CITY OF PORTLAND BUILDING PERMIT

Job ID: 2012-11-5394-DRG

has permission to Build new 1 story, 2 car garage (42 Obrion)

Conditions of Approval:

3.
2.
1.
REVS:
CODE: IRC 2009
TOWN: Portland
DATE: 11-02-12
SCALE: As Noted
DESIGNED:
DRAWN: JJO
TITLE: First Floor & Foundation Plan
FILE:
SHEET: A1.01

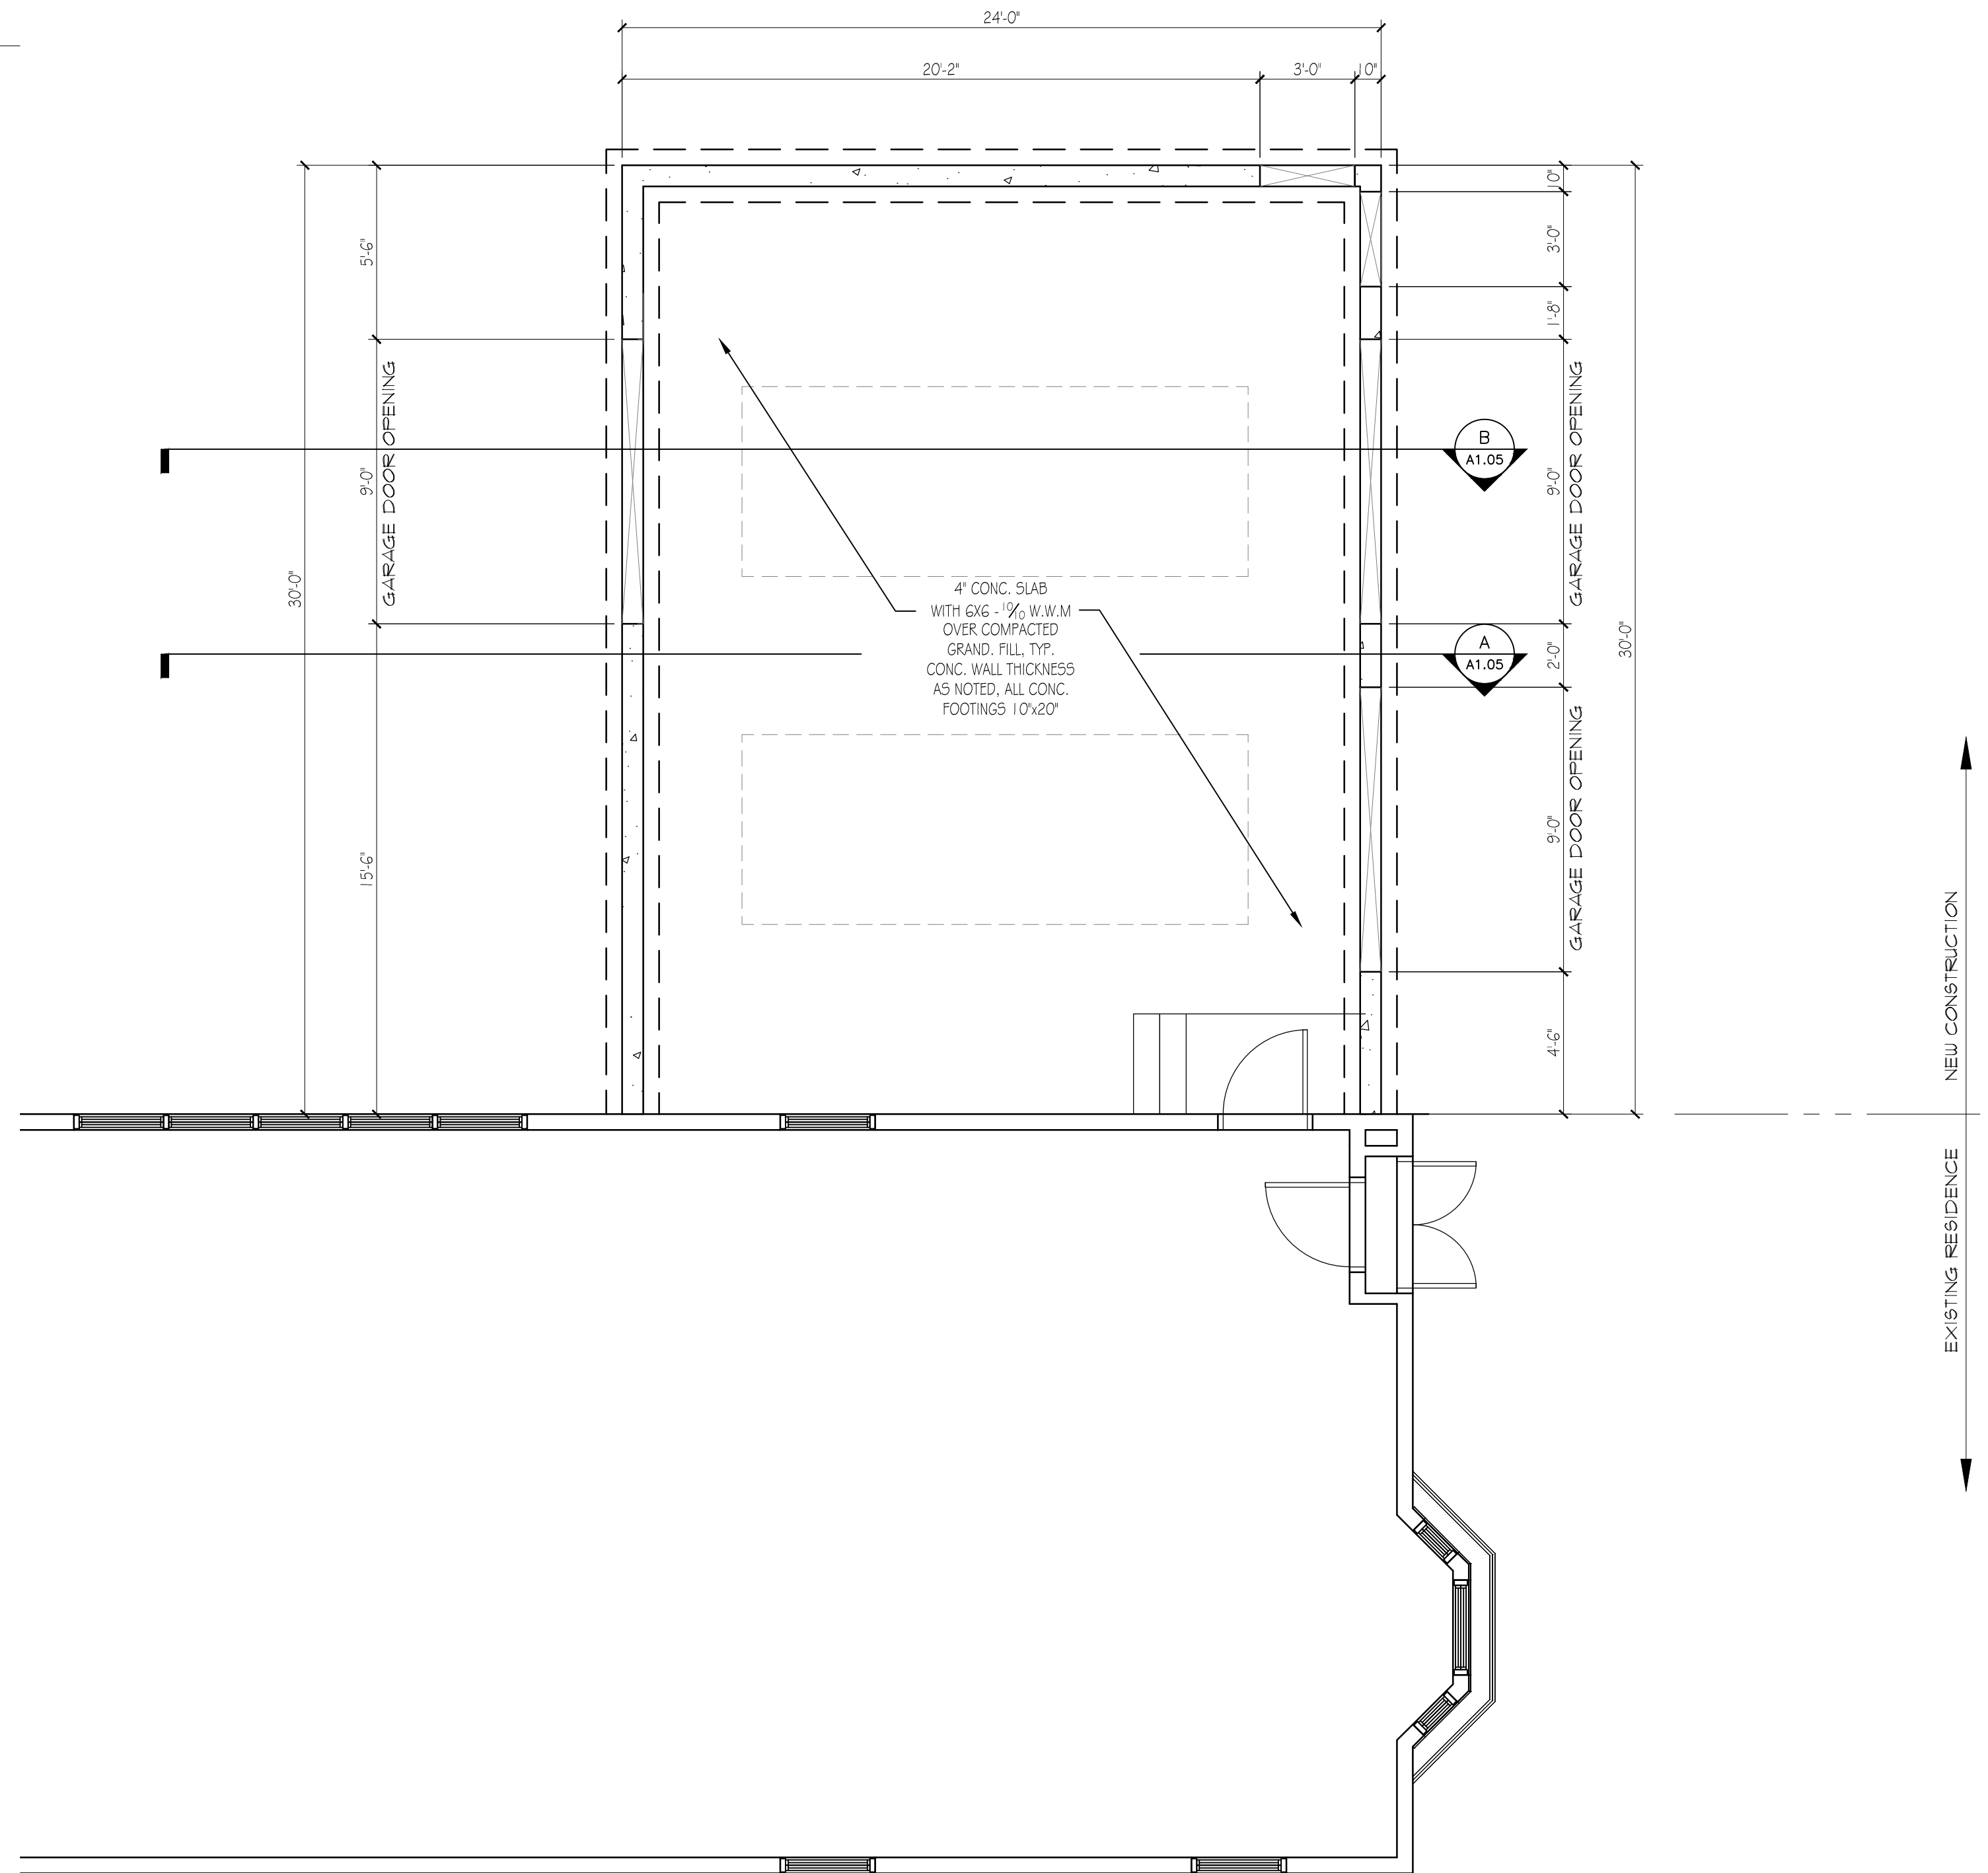
3. As discussed during the review process, the property must be clearly identified prior to pouring concrete and compliance with the required setbacks must be established. Due to the proximity of the setbacks of the proposed addition, it may be required to be located by a surveyor.

3.
2.
1.
REVS:
CODE: IRC 2009
TOWN: Portland
DATE: 11-02-12
SCALE: As Noted
DESIGNED:
DRAWN: JJO
TITLE:
Remodeled Sections
FILE:
SHEET: A1.05

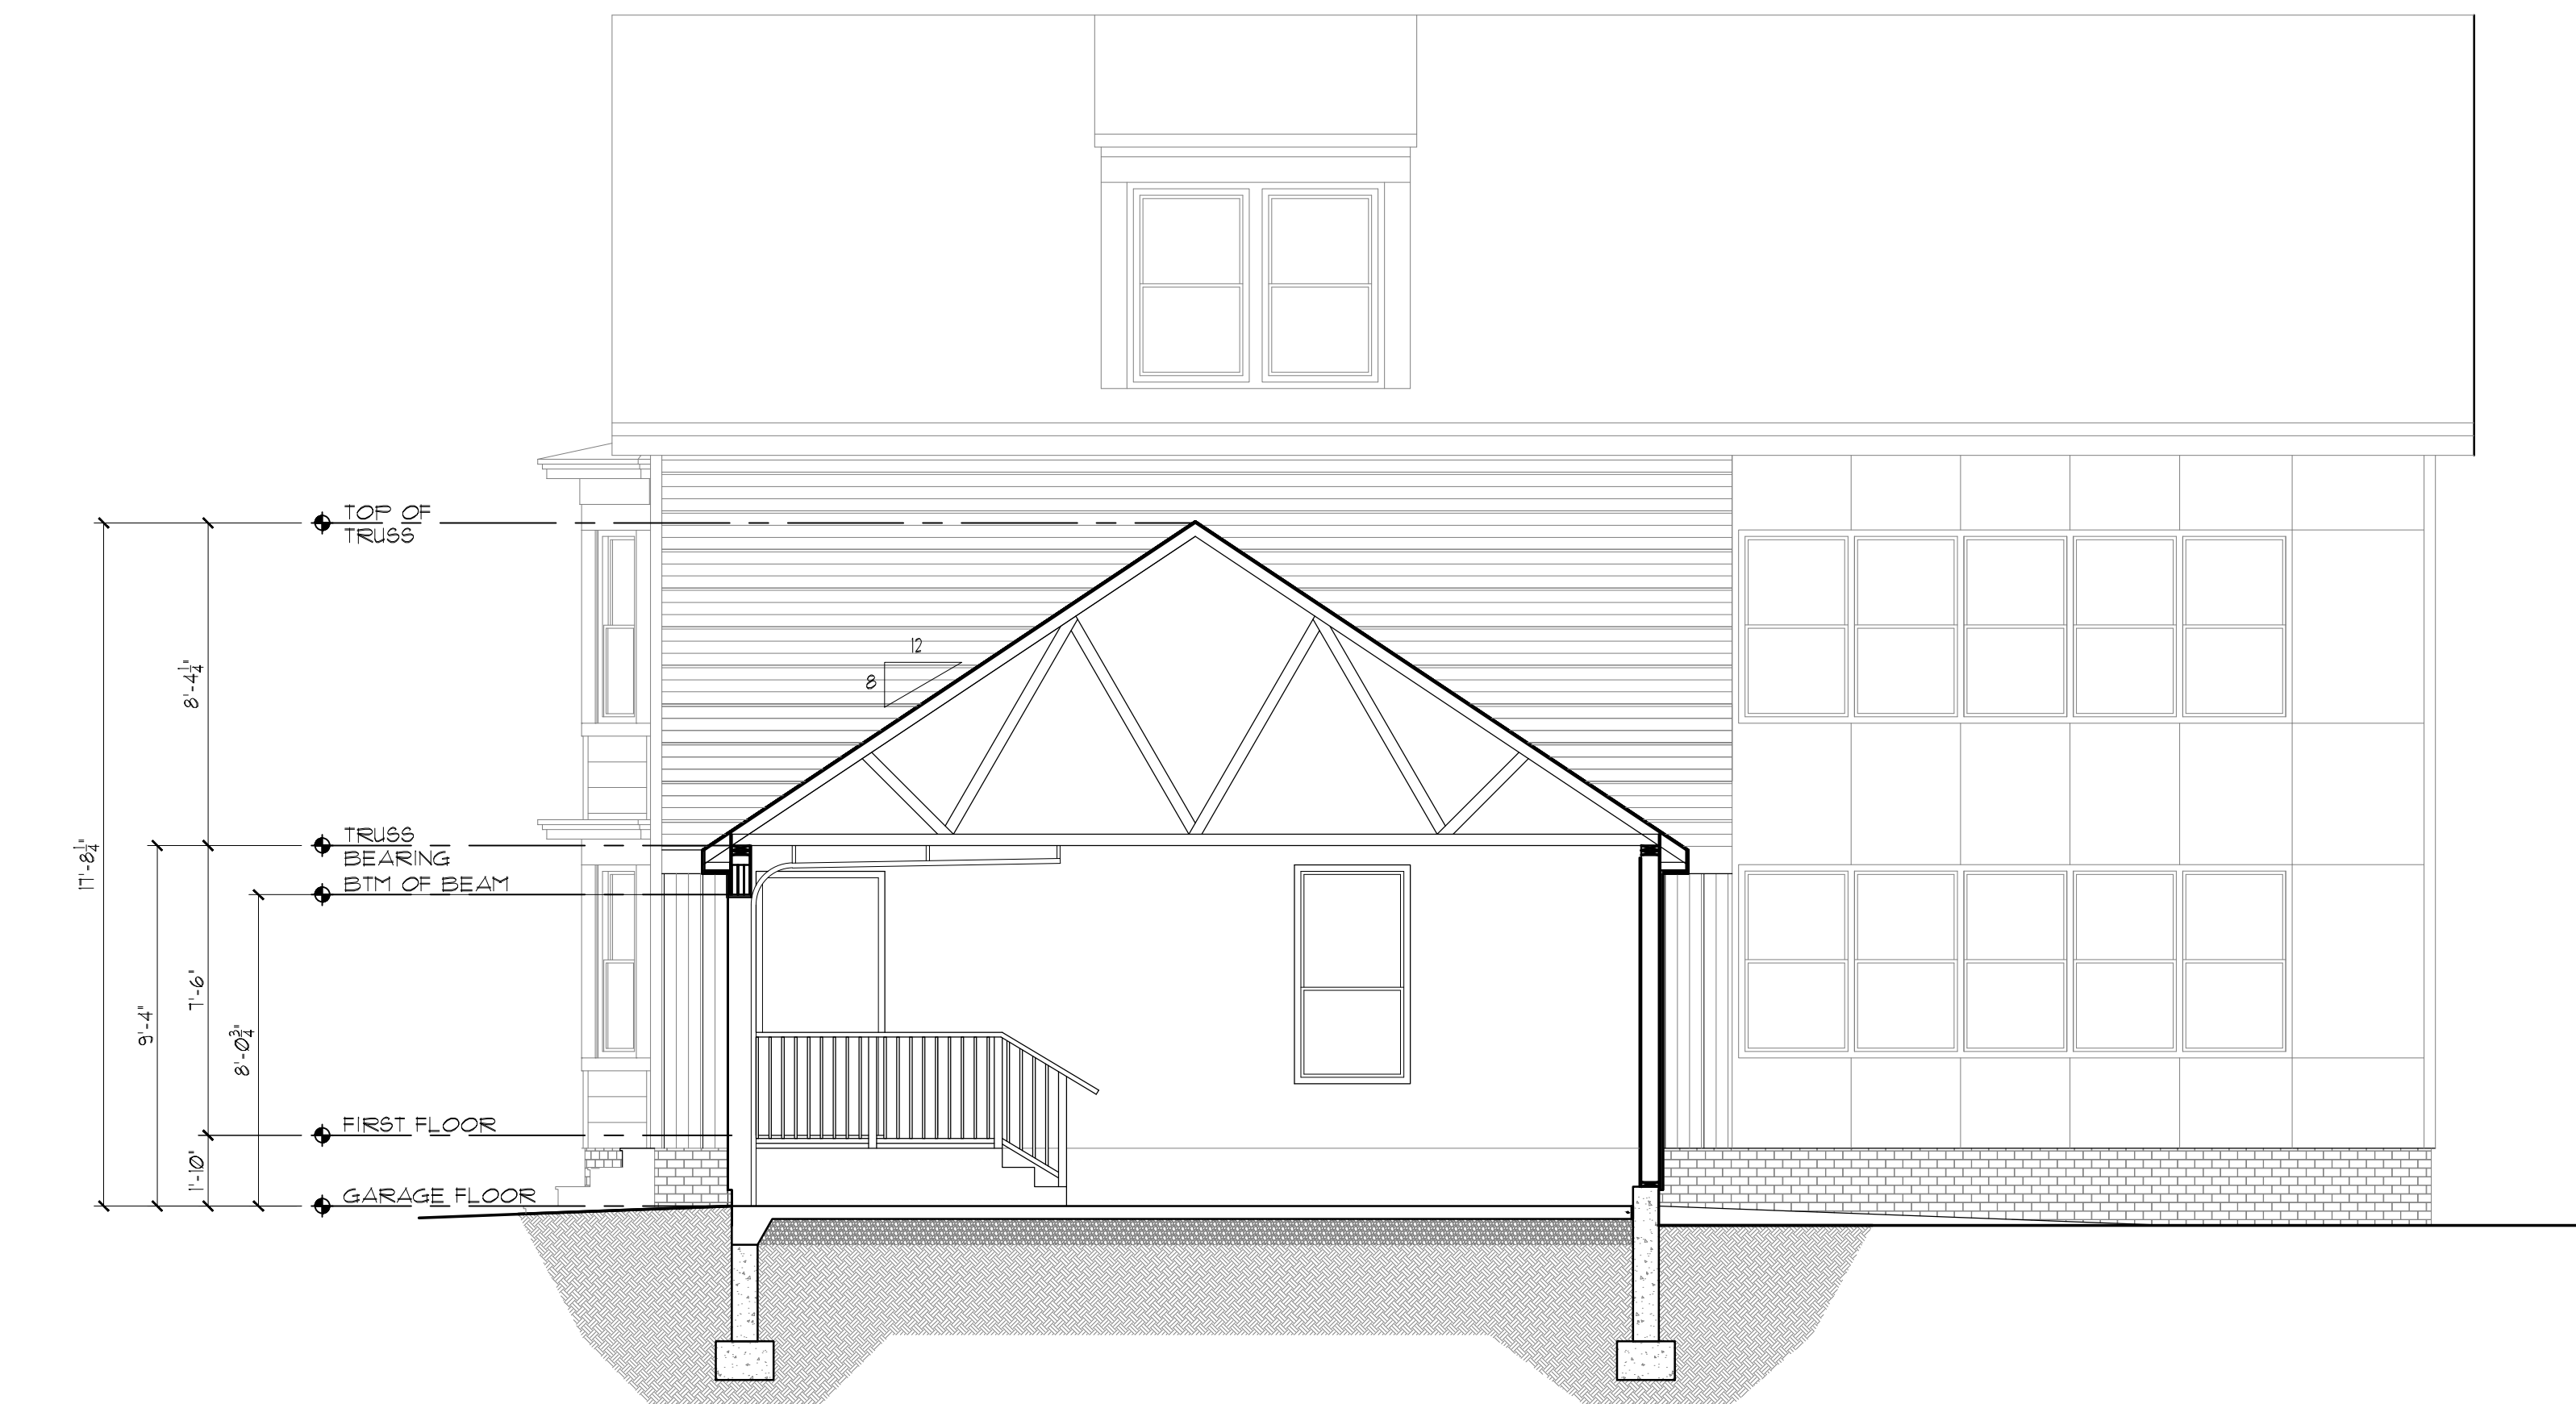
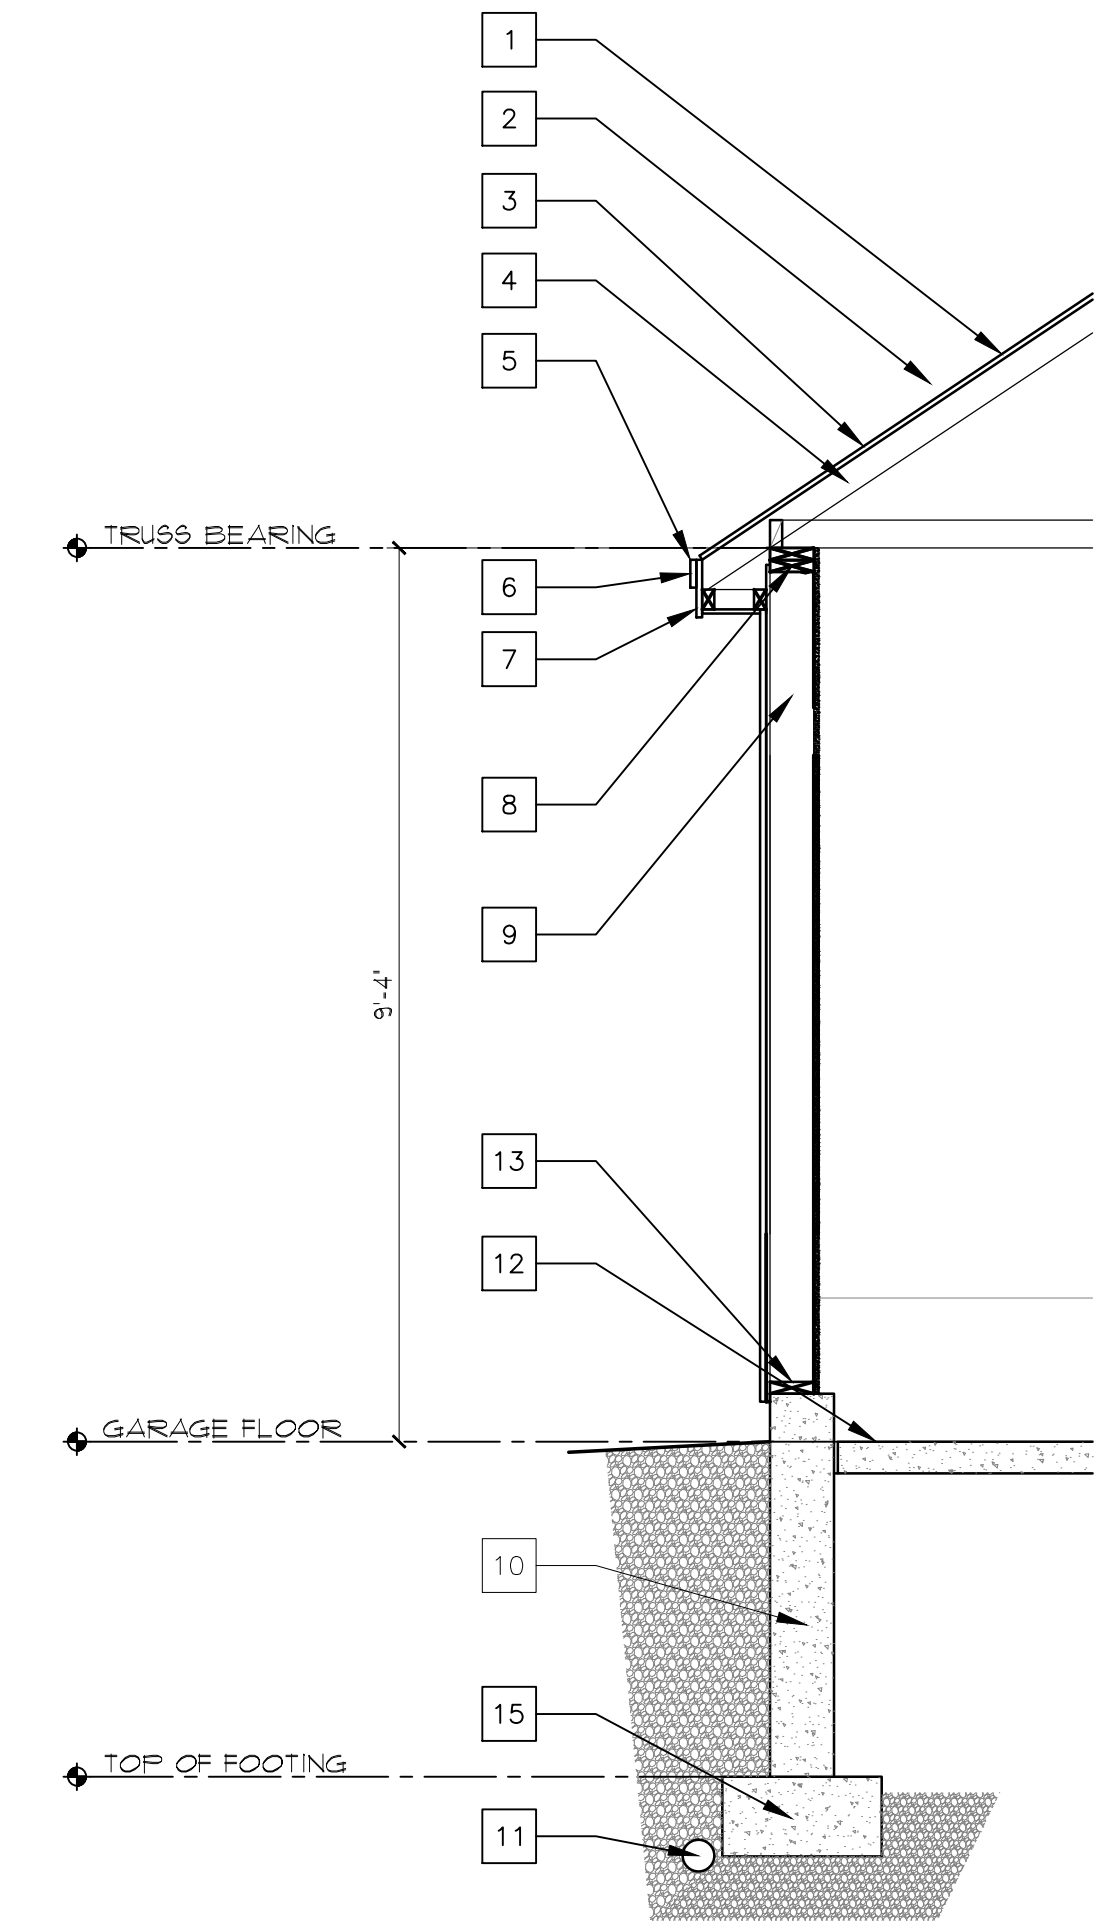
4. Submit specifications for engineered trusses and floor joists prior to construction.
